Your Ref: OWPC4976
Our Ref: FG/10/15/HH 26-01-2015
Please ask for:
Ross Leal

Alterations to existing south facing front dormer window, new west facing dormer in side elevation & 5 No. new velux roof lights to front & side elevations
9 Guernsey Road Ferring

SIDE (w)

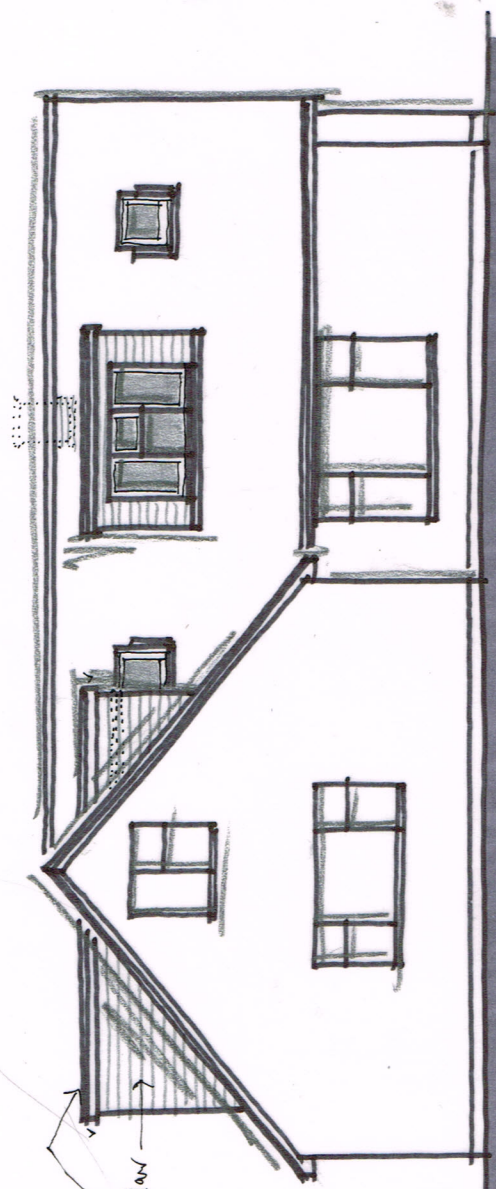
The concern is the west side dormer window & two velux windows which look straight down into our lounge area, denying us our privacy. On viewing the plans there is an existing South facing window in the same room.
